Application for a non-material amendment following a grant of planning permission.

Number	17
Suffix	
Property name	
Address line 1	Stewards Rise
Address line 2	
Address line 3	
Town/city	Arundel
Postcode	BN18 9ER
Description of site location must be completed if postcode is not known:	
Easting (x)	500658
Northing (y)	106443
Description

Single storey front/side/rear extension, dormer to side to create additional habitable roofspace and landscaping to front to create 2 additional car parking spaces

Reference number:	AB/46/19/HH (PP-07832915)
Date of decision	30/08/2019

17SRPRELE2021-R01
17 Stewards Rise - Arundel
Revised Proposed Elevations
Scale 1:100 @ A3 (2021)

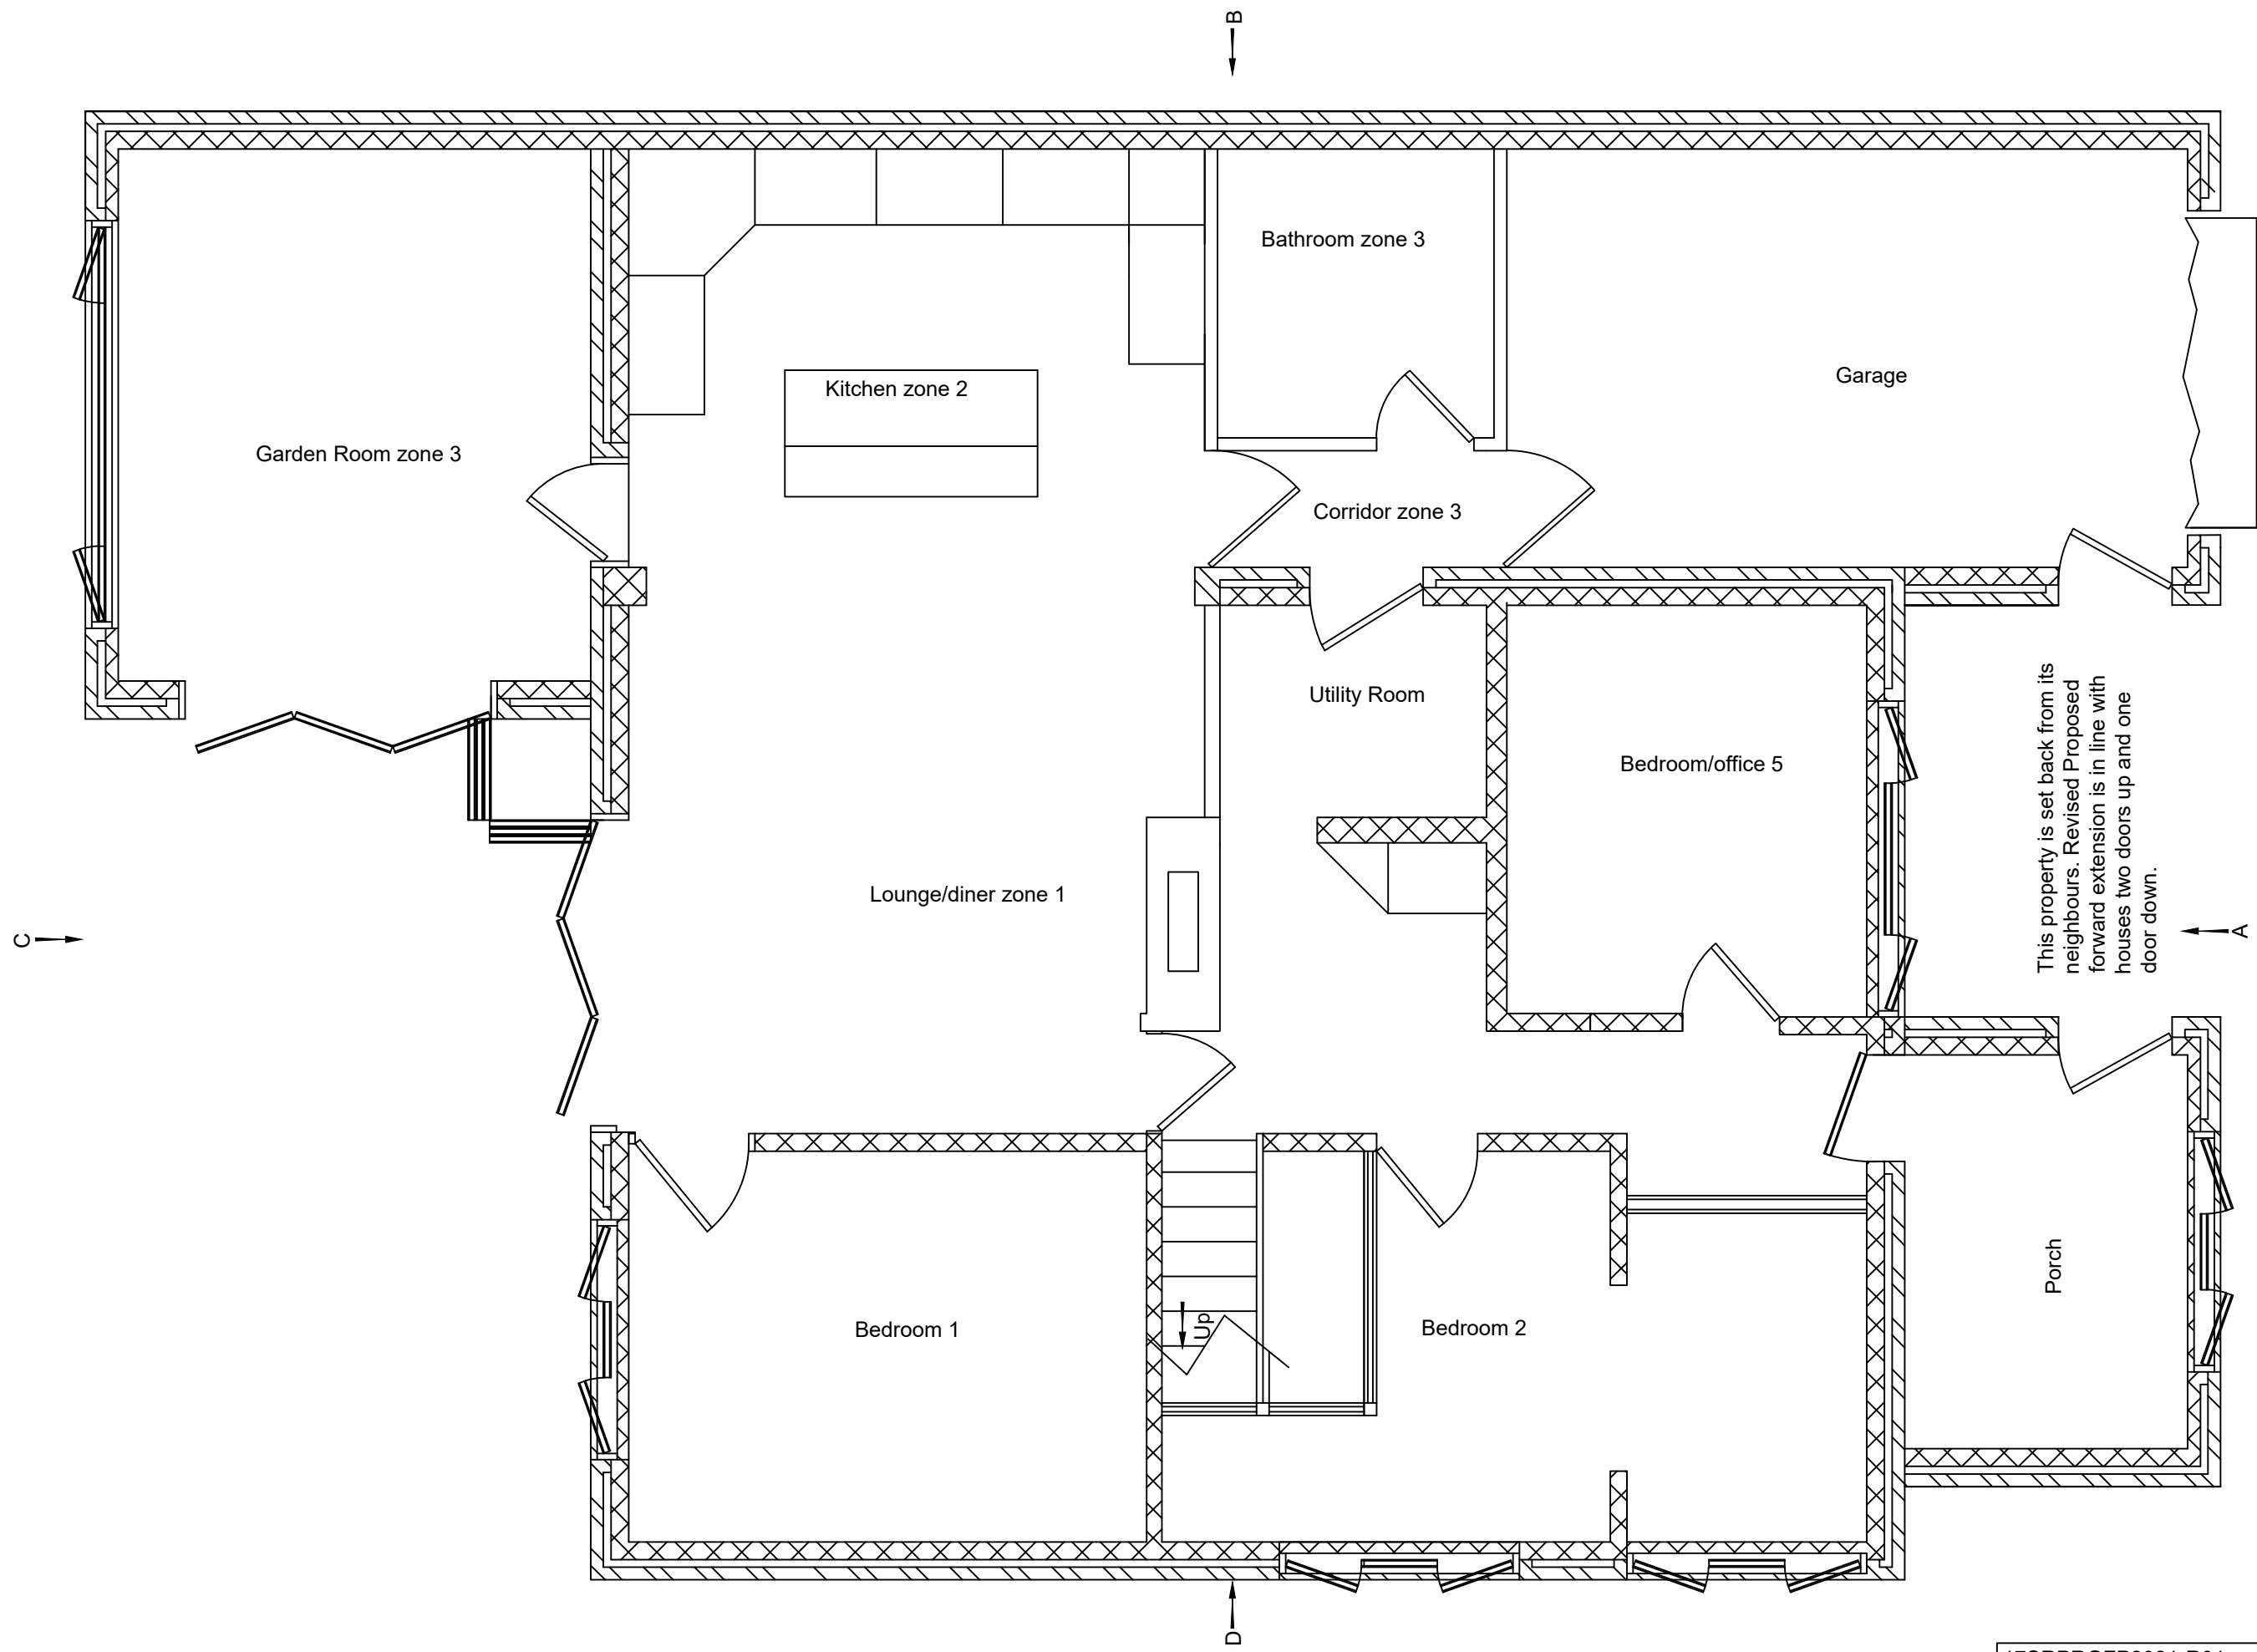
Reduction in rear extension with the removal of the conservatory. Rear extension only to have flat roof with lantern. The side and front extensions are unchanged.
